Response to Planning Application

From: Arun District Council Greenspace

Application ref: Y/146/20/RES

Description: Application for approval of reserved matters for the erection of 45 dwellings pursuant to Section 73 permission Y/13/18/PL (following the grant of outline planning permission Y/49/17/OUT) (resubmission following Y/39/20/RES). This application may affect the setting of a Listed Building.

Detailed Planting Plan - Sheet 1 of 2

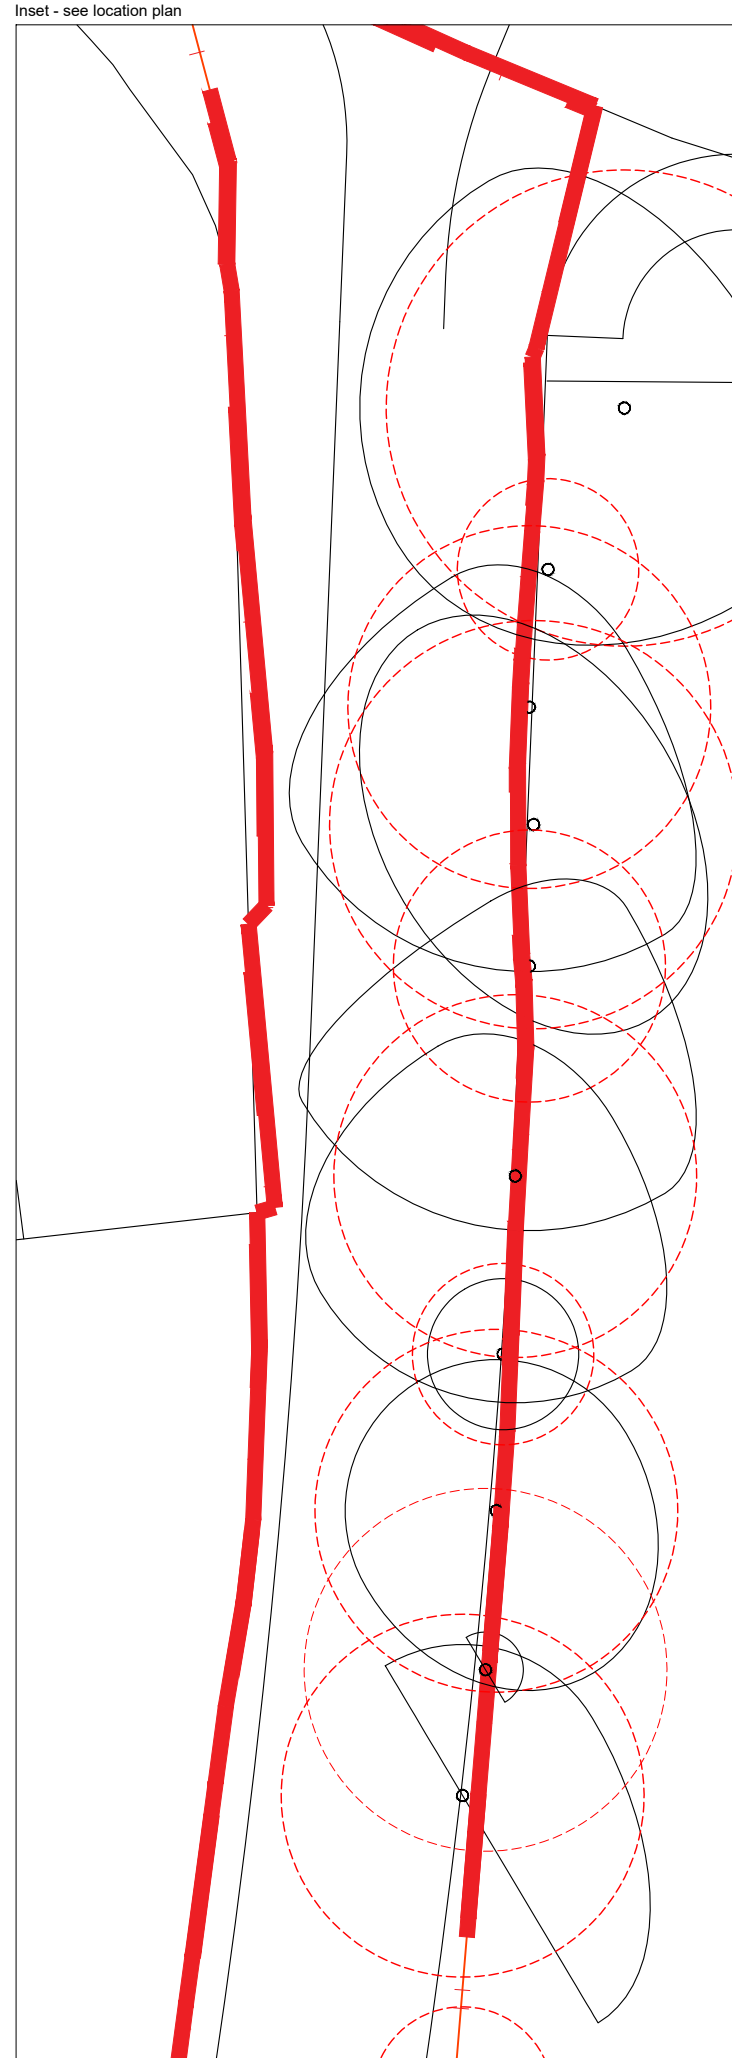
This response relates to the submitted detail contained in Coloured 0100 PL06 site layout and Detailed Planting Plans sheets 1 and 2 of 2 0301/0302 Rev PL06 and landscape Management and Maintenance specification.

I can confirm that the information submitted has provided a well thought out scheme which is fitting for location providing a good mix of native and ornamental trees and shrubs with suitable planting densities and size at time of planting. The two areas of POS with these proposals are suitably located and provide dwellings with direct access to these areas. The buffer area to the perimeter site boundary has the potential to aid and enhance wildlife and biodiversity habitat. This has been met by the introduction and inclusion of native understory and buffer forming planting mixes.

Detailed Play Provision - LAP

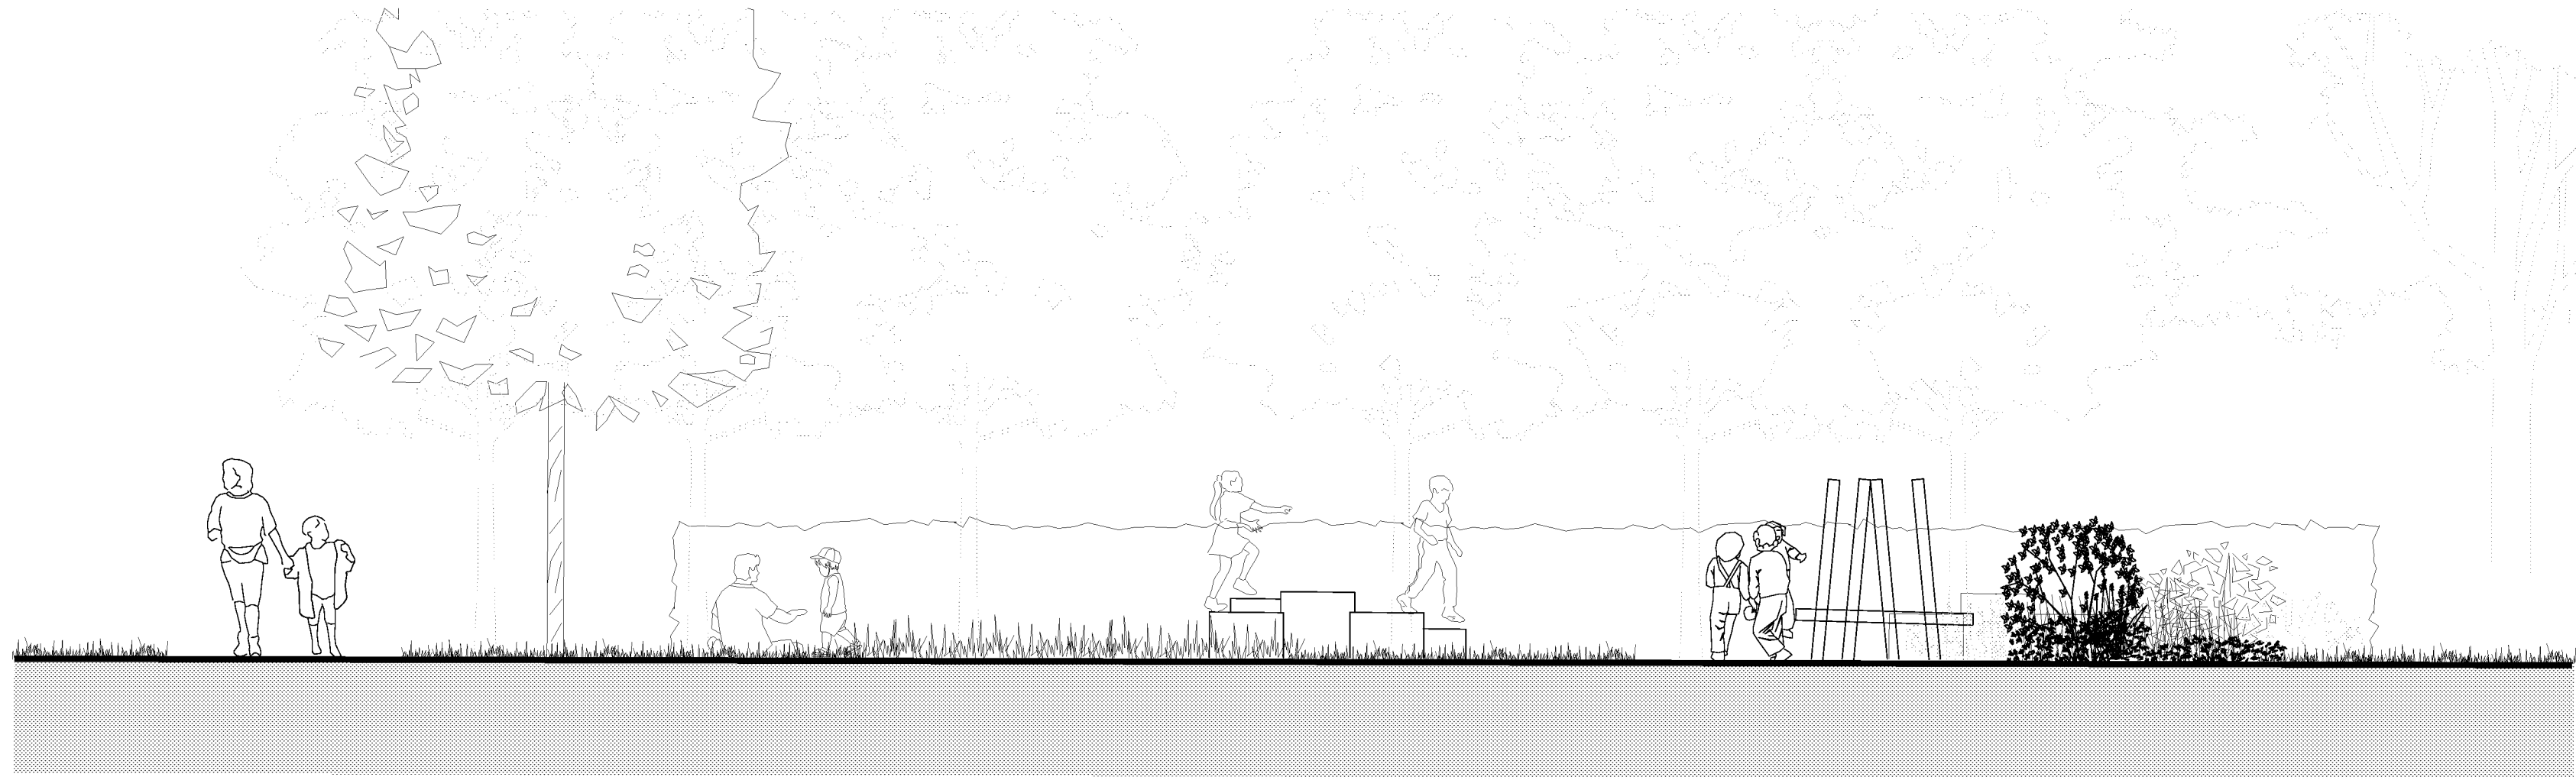
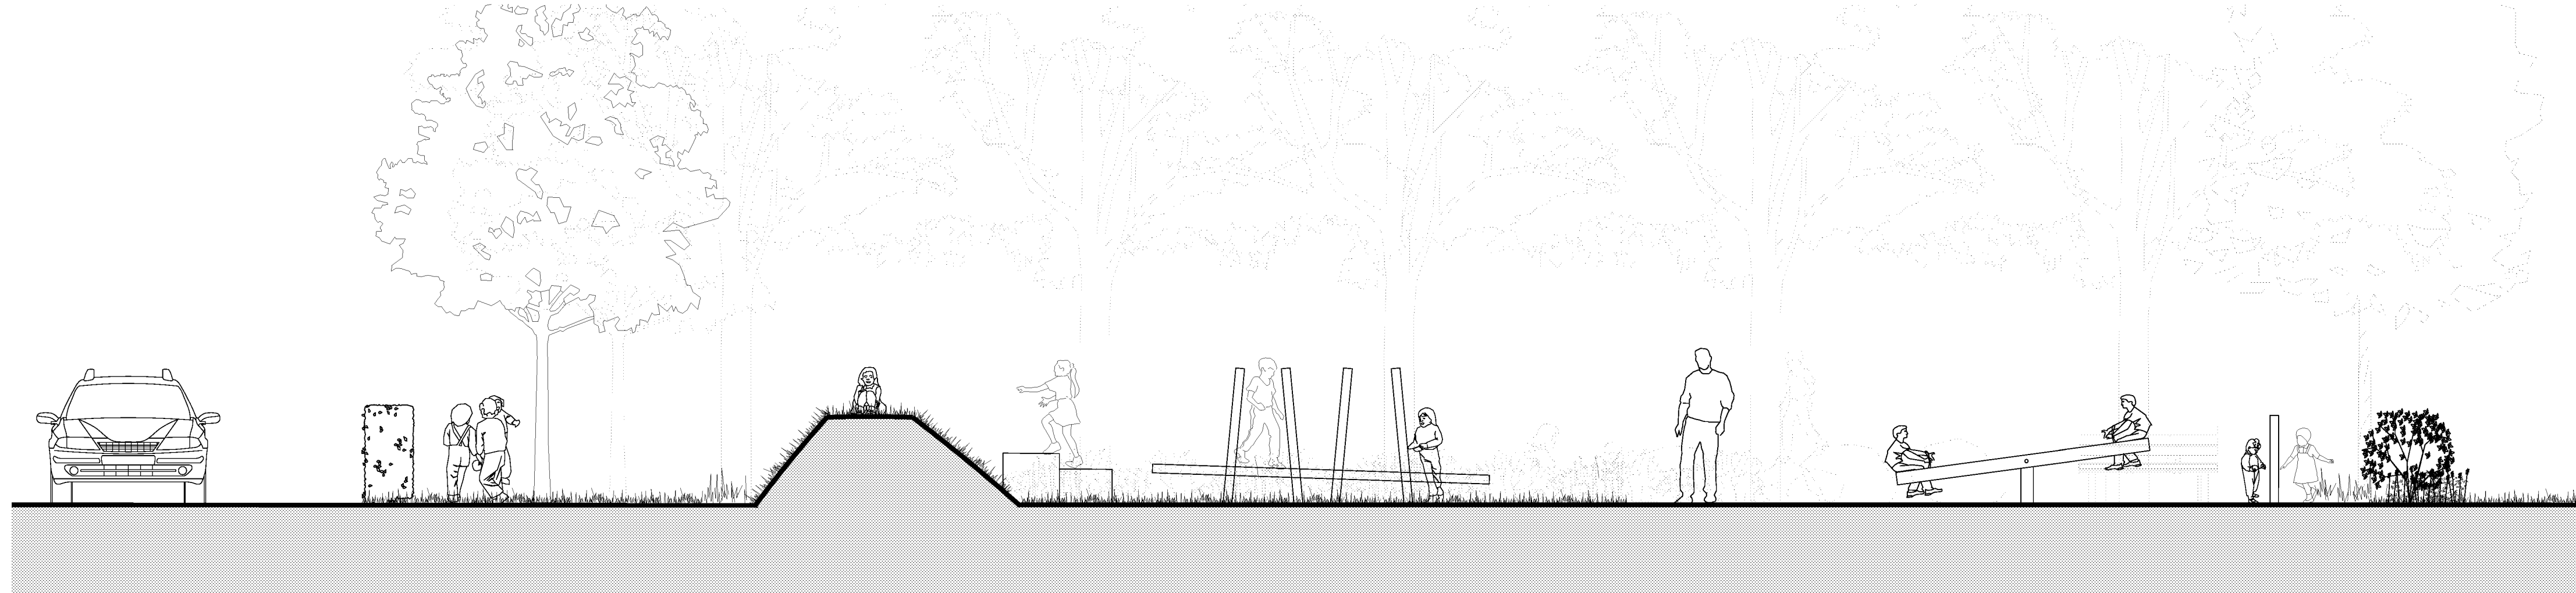
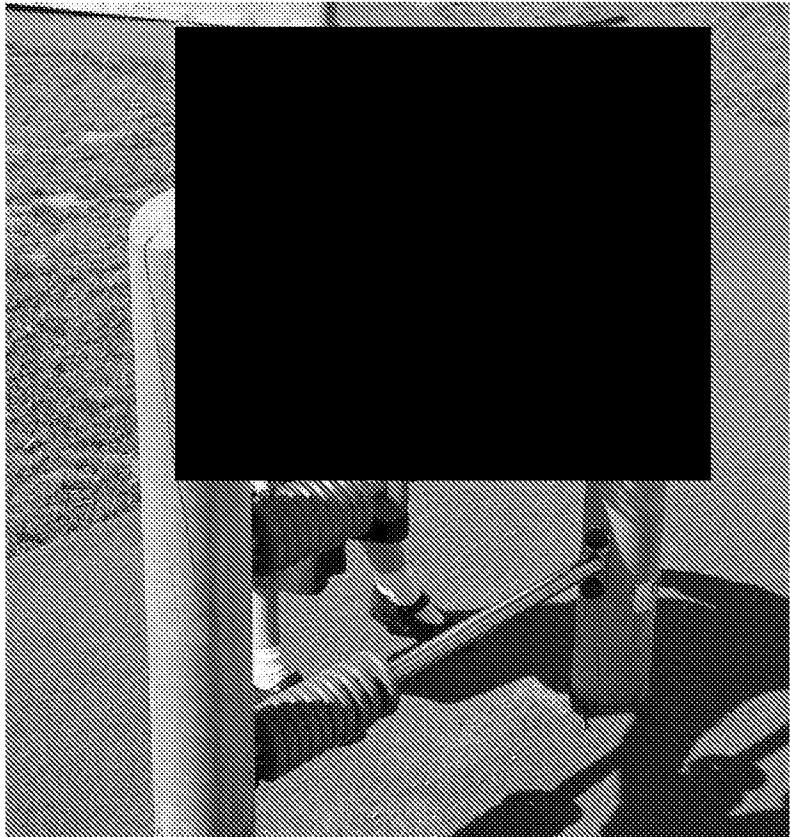
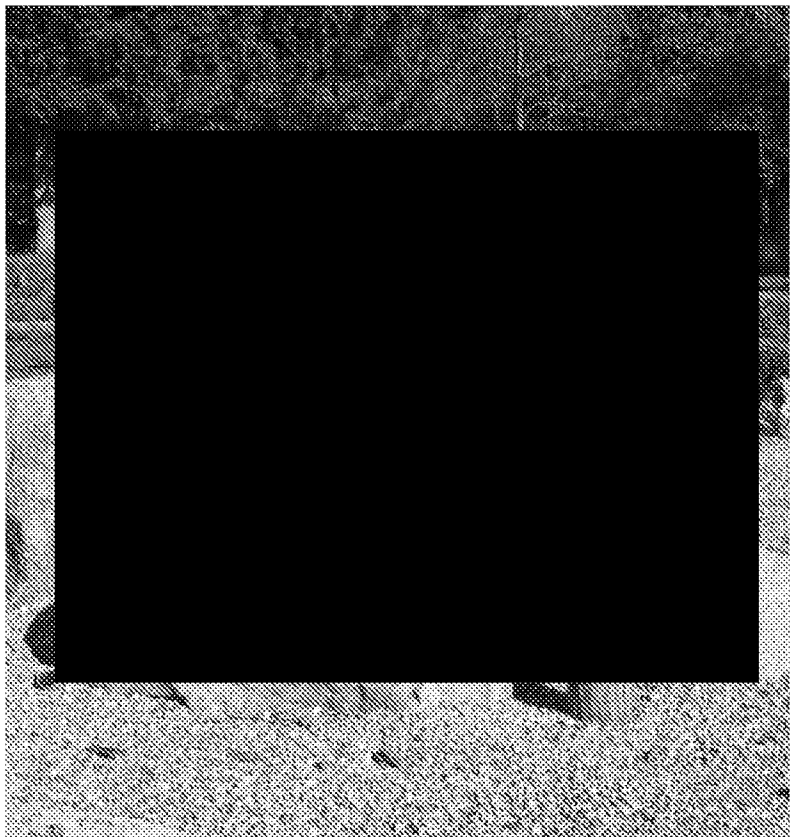
The drawings show the inclusion of LAP towards the entrance of the site. I am satisfied that this is suitable for location with detailed plans which show the proposals for this area and the provision offered. I would note that the safety surfacing for this area on dwg 0503 PL05 has been detailed as CED Play gravel which whilst suitable for application would not be the desired choice if it were to be maintained by the LPA due to maintenance issues.(Confirmed as Management Company Maintained)
